Sent: 11 November 2011 10:12
To: Planning
Subject: Comments Added: 22 Kingswell Ride, Cuffley

Application ID: S6/2011/1869/FP Mr M Peacock Application Owner: Welwyn & Hatfield Borough Council(Development Control Officer)

Location: 22 Kingswell Ride, Cuffley

Description: Alterations to roof to include two side dormer windows Comment Added:

Drawing: **Sections & Elevations**

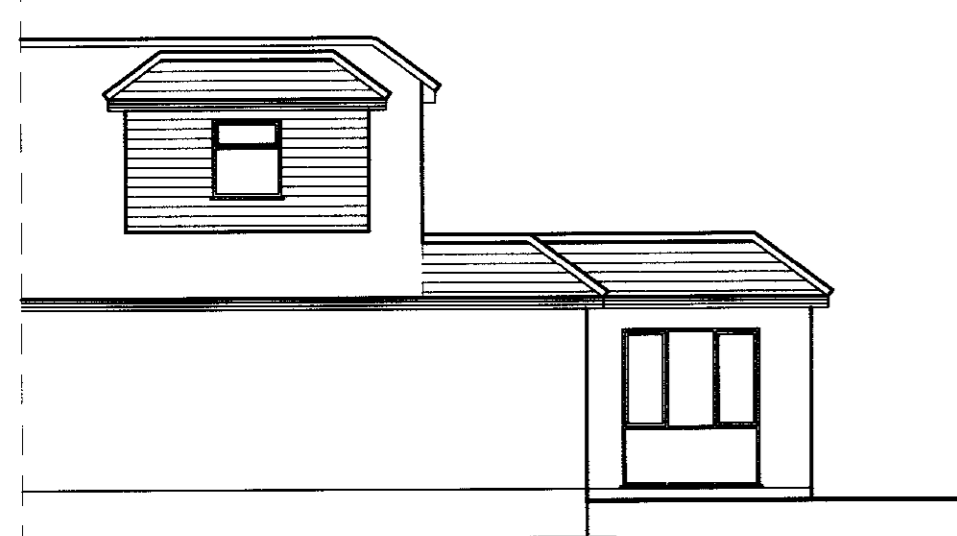
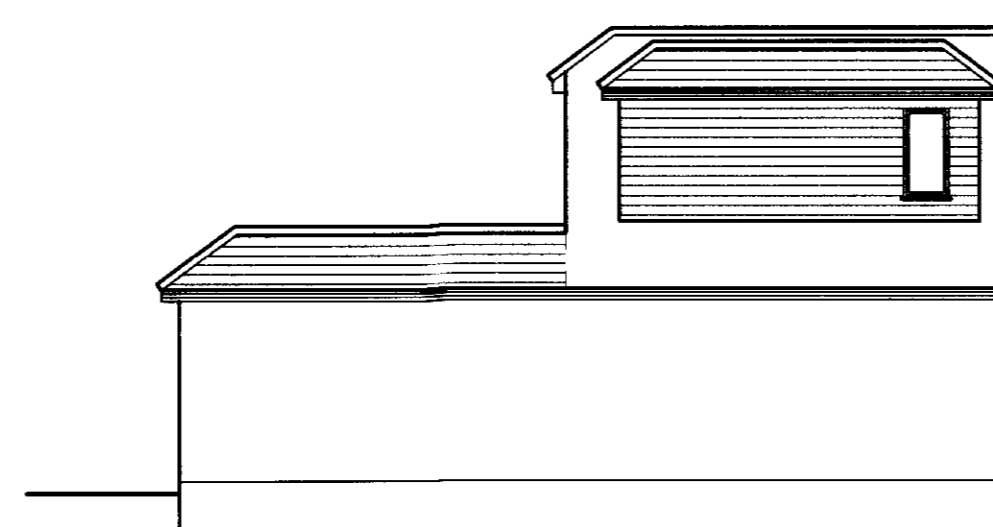
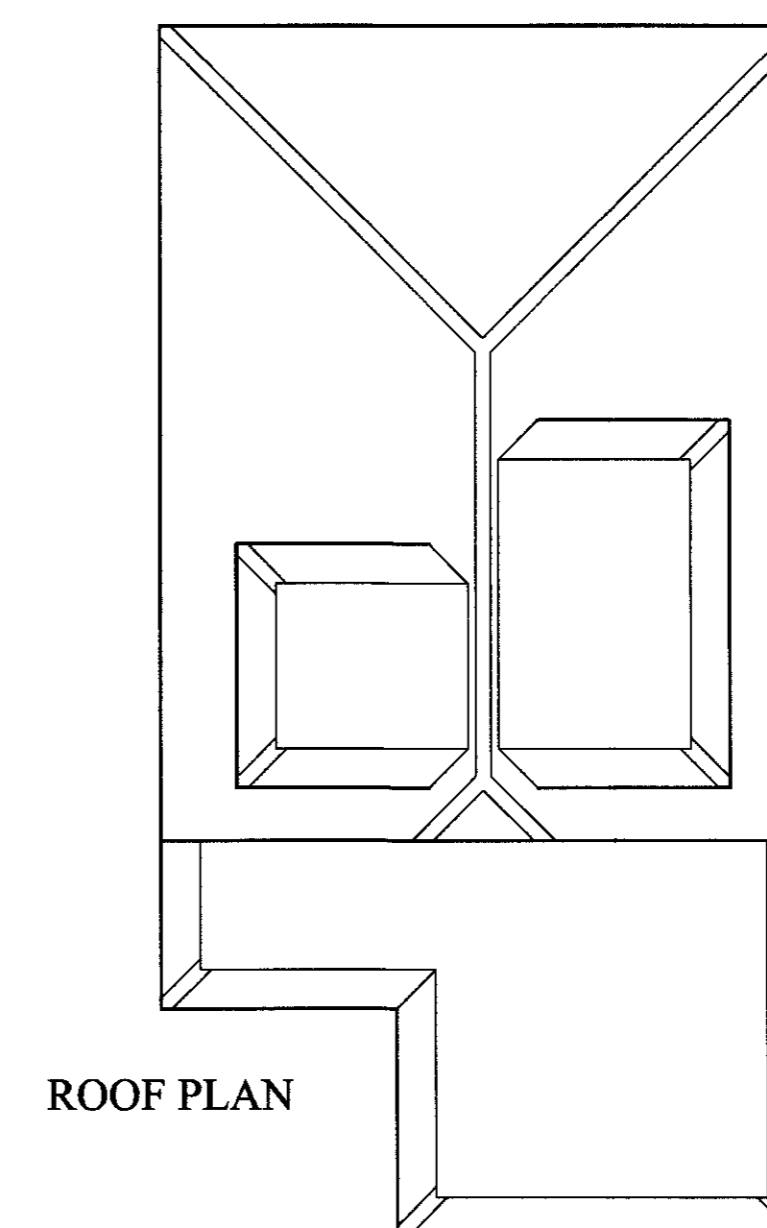
Comment: The PC have concerns that this application makes a large addition to plans already granted and may cause overlooking implications for the neighbours.
